DOC17/228987-1
MP 06 0250 MOD 9

Review of Fern Bay Residential Subdivision - Modification 9 - Response to Submissions

I refer to your e-mail dated 13 April 2017 inviting the Office of Environment and Heritage (OEH) to review the proponent's comments on OEH's Response to Submissions advice for the project modification of the residential subdivision at Seaside Boulevard Fern Bay (MP 06 0250 MOD 9). OEH's review of the letter from Cardno dated 12 April 2017 was informed by the attachments and resources provided on the Department's Major Project Assessments website.

SCALE	1: 1000	DRAWING TITLE	STAGES 18 & 19 DETAIL PLAN REV L
REVISION DATE	01/11/2016	DEVELOPMENT	PROJECT PLAN L
PLOT DATE	01/11/2016	DRAWN/CHKD BY	FERM BAY SEASIDE VILLAGE
DA NUMBER		IMC / AED	NELSON BAY ROAD, FERN BAY
		CC NUMBER	CLIENT
			RAWSON COMMUNITIES PTY LIMITED

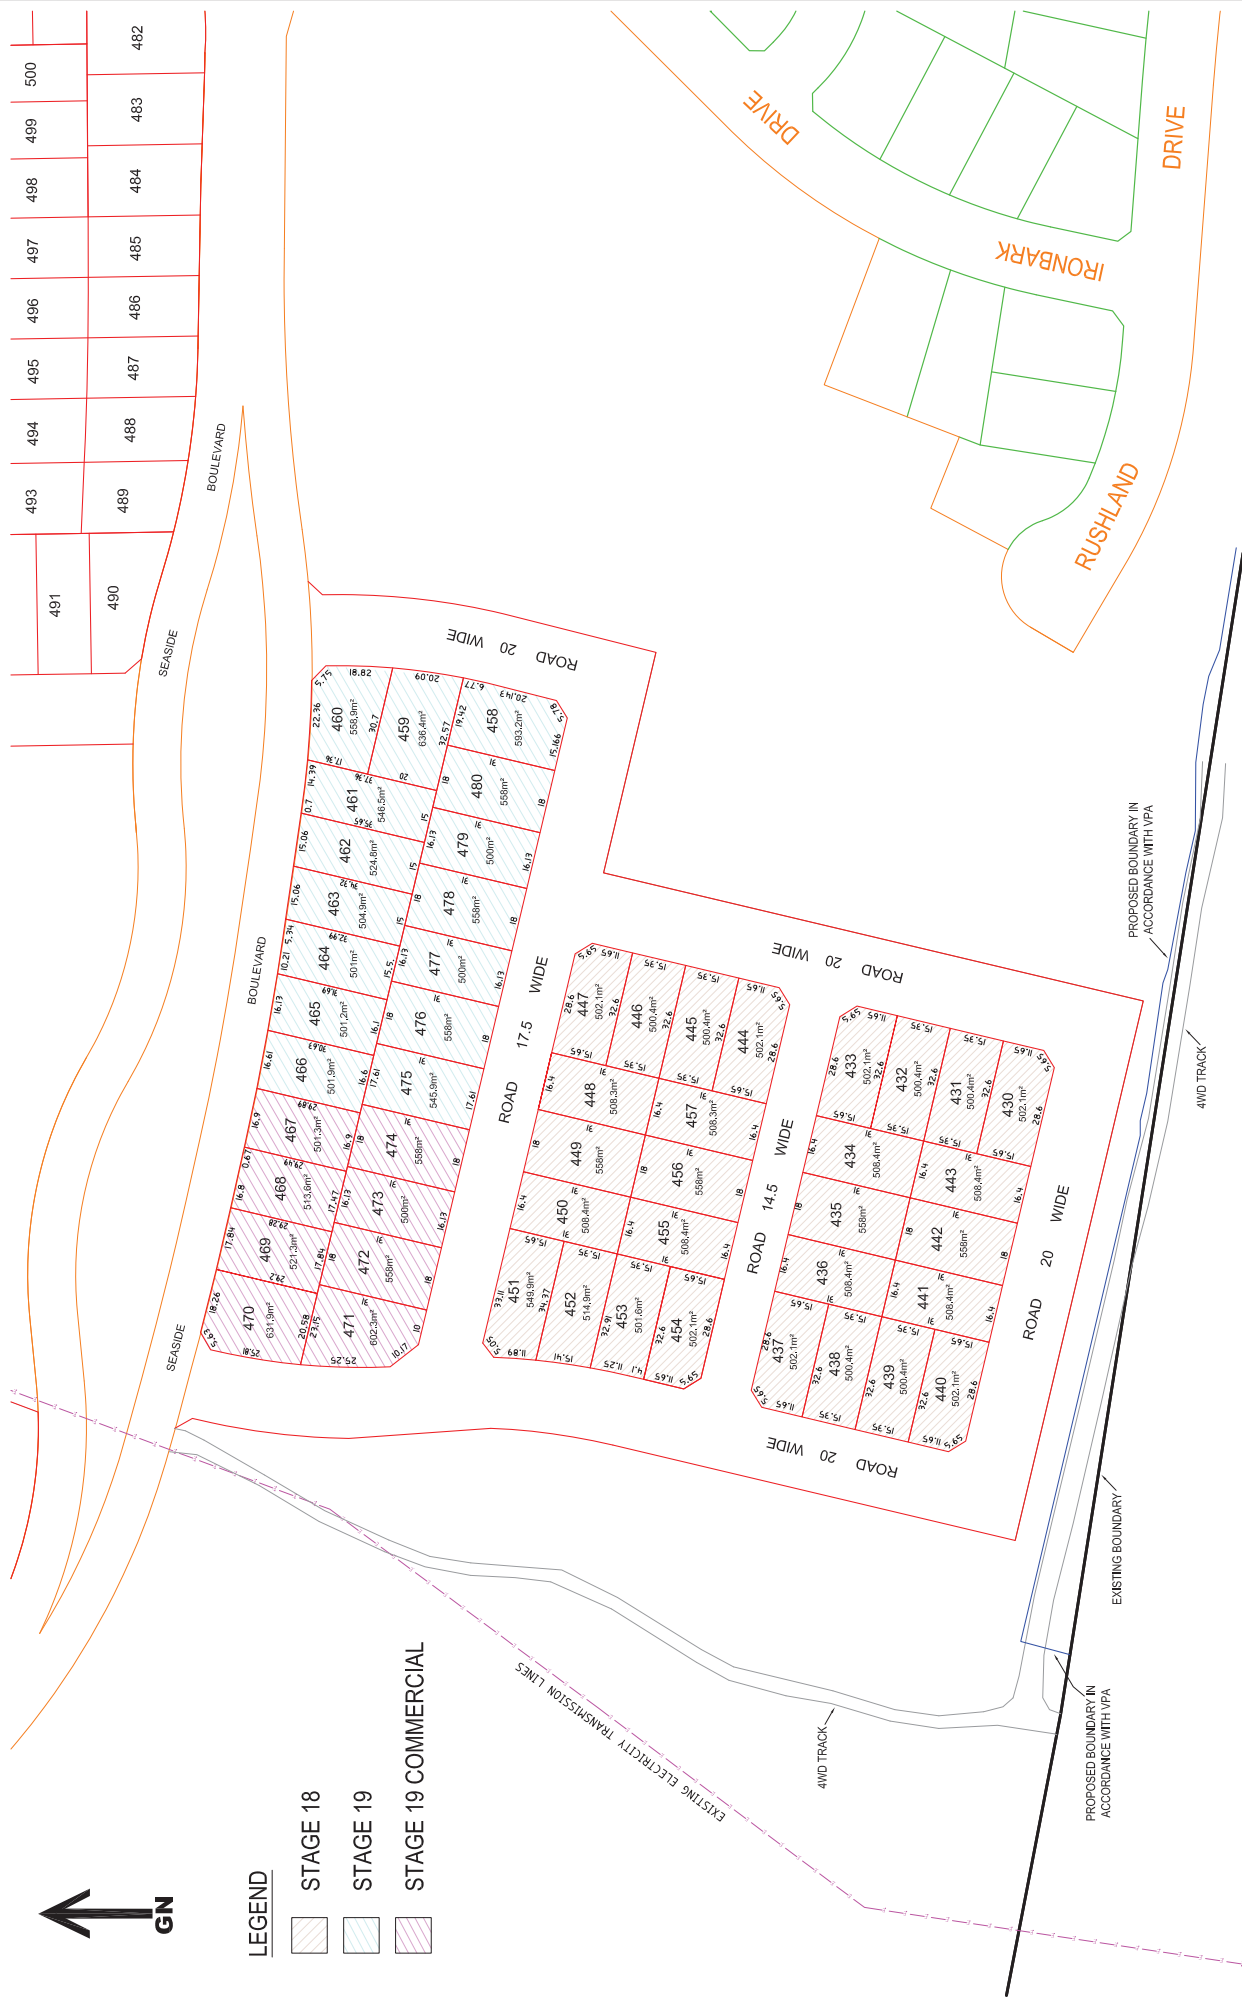
The proposed adjusted boundary with the Worimi Conservation Lands (WCL) needs to be shown on all plans for stages 18 and 19, and should be included as a condition of approval. This is needed to enable NPWS to conduct a proper assessment for issues that may exist due to the close proximity of stage 18 to the WCL, and in particular the 4WD track located along the boundary. This is relevant to the next matter listed below.

NPWS is not able to determine the location of the retaining wall, and any land required for maintaining the retaining wall, in relation to the existing WCL 4WD access track and its bollard line. The WCL boundary adjustment in this location, as required under the Voluntary Planning Agreement (VPA), needs to include adequate land to enable NPWS to complete maintenance works on the bollard line and 4WD track without impinging on the development site. It is not clear to NPWS whether this outcome can be achieved in conjunction with the commitment to locate the retaining wall (and any associated land required for its maintenance) within the development site. This situation needs to be clarified prior to any determination of the Modification Application.

Given the proximity of the retaining wall to the WCL boundary, and in particular the 4WD access track, NPWS request the opportunity to review the standard of the retaining wall, given the large difference in elevation between stage 18 and the WCL at this location. NPWS also note that there is considerable potential risk to the 4WD access track at the time earthworks are carried out to prepare stage 18, and prior to the construction of the retaining wall. NPWS require certainty that this risk will be properly mitigated and that there will be no impact to WCL infrastructure, including the bollard line and 4WD access track, during earthworks and construction activities prior to or as part of any determination of the Modification Application.

20 OF 21

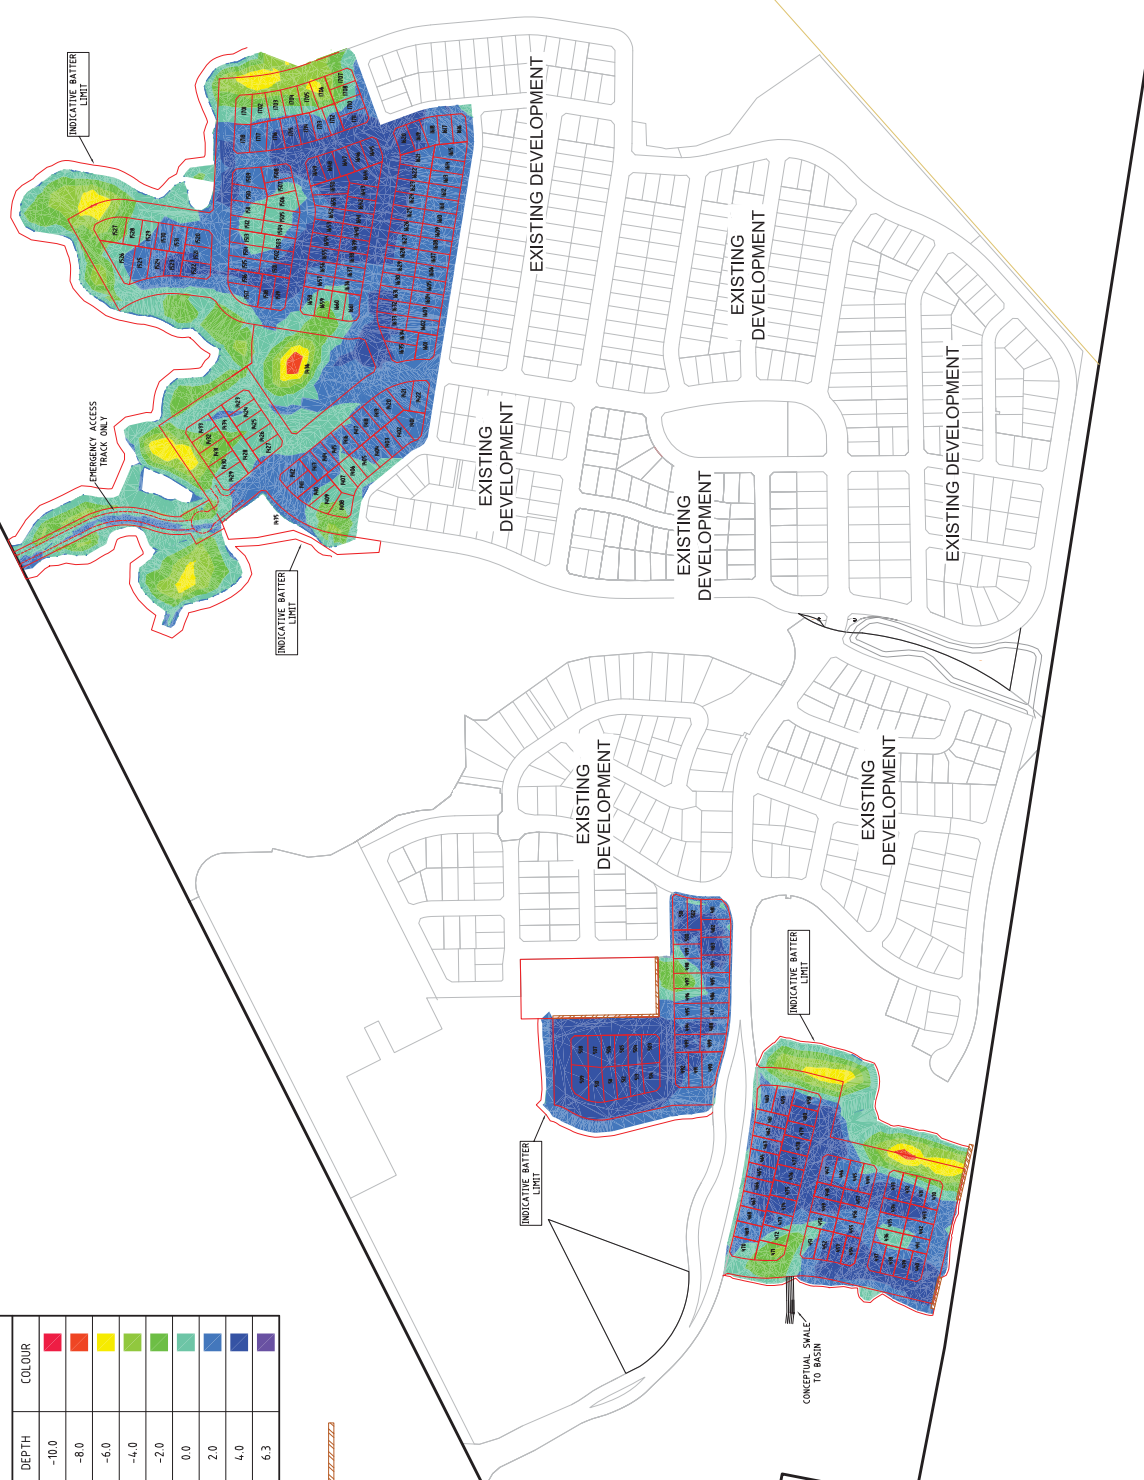
The issues raised by OEH in correspondence dated 14 December 2016 (Ref: DOC16/609769-2) do not appear to have been addressed. OEH previously indicated that the modifications would impact on the biodiversity of areas included as conservation zones in the Vegetation Management Plan and zoned E2 for conservation. It is noted that the impacts will be caused not only by encroachment of roads into the E2 zones, but also from the considerable amount of cut and fill which would be required within the E2 zones to enable the development to proceed. This is clearly indicated in Figure 29850 L Bulk Earthworks (Cut-Fill) Plan REV-L.

OEH's preference is that there are no impacts to biodiversity in the E2 zone. However, OEH's previous advice was that if this was considered unavoidable, the impacts would need to be quantified, justified and offset according to the major projects offset policy. OEH's request for this assessment, as well as a consideration of the impacts on the hydrology of the conservation zones and connectivity of the vegetation, has not been adequately addressed. The proponent's comments on OEH's Response to Submissions advice acknowledges only minor incursions to the E2 zone and states that OEH "...raised no concerns with regard to ecological impacts of the Modification Application...".
